App no: 23.0353

Address: Equestrian Centre Higher Trapp House Trapp Lane Simonstone

Proposal: Redevelopment of existing equestrian centre to form horse stables and livery, indoor arena and external riding area, including the demolition of the existing dilapidated building (pursuant to variation of condition 5 on permission 3/2015/0283) to allow for commercial enterprise use.

The submitted documents and plans have been reviewed and the following comments are made.

Proposed Site Layout and Sections

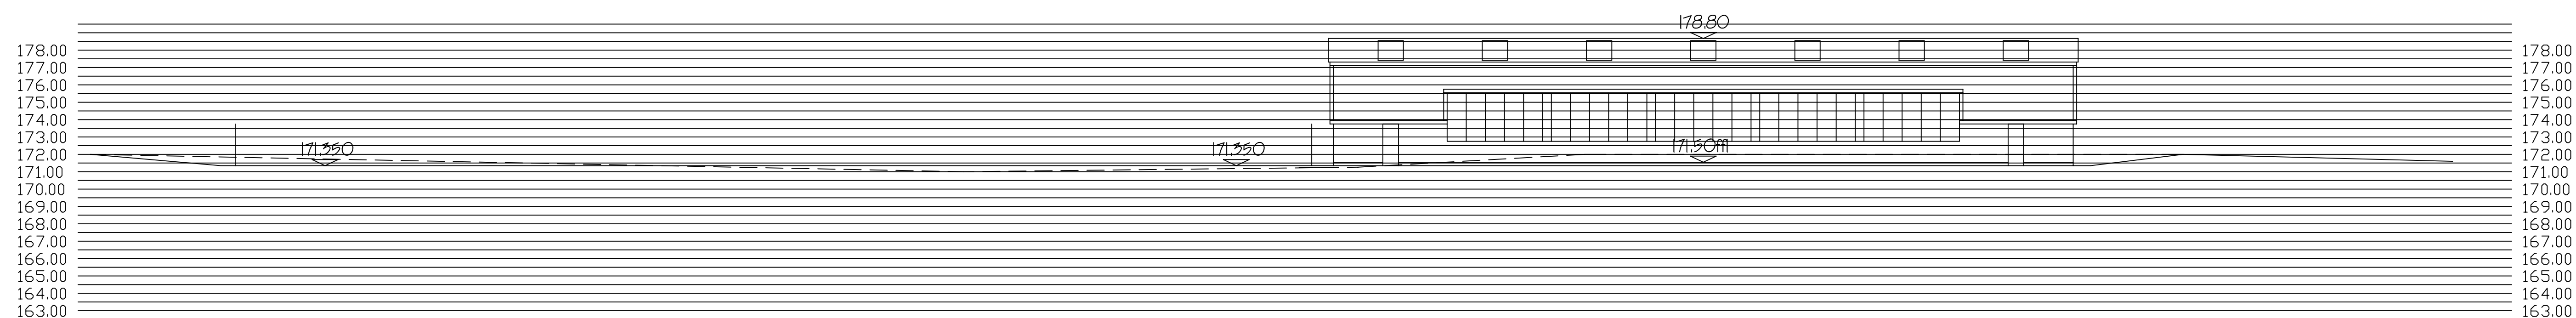
The existing site access is paved and with gates set back from the edge of the highway and is considered suitable to accommodate the vehicles generated by the proposal.

There are no parking plans submitted, there is evidence of large areas of hardstanding which would allow parking and turning of vehicles. There is reference to, in the original highway comments, 24 car parking spaces and 10 light goods vehicle spaces. For completeness a parking plan is requested to show staff and client parking required for the development.
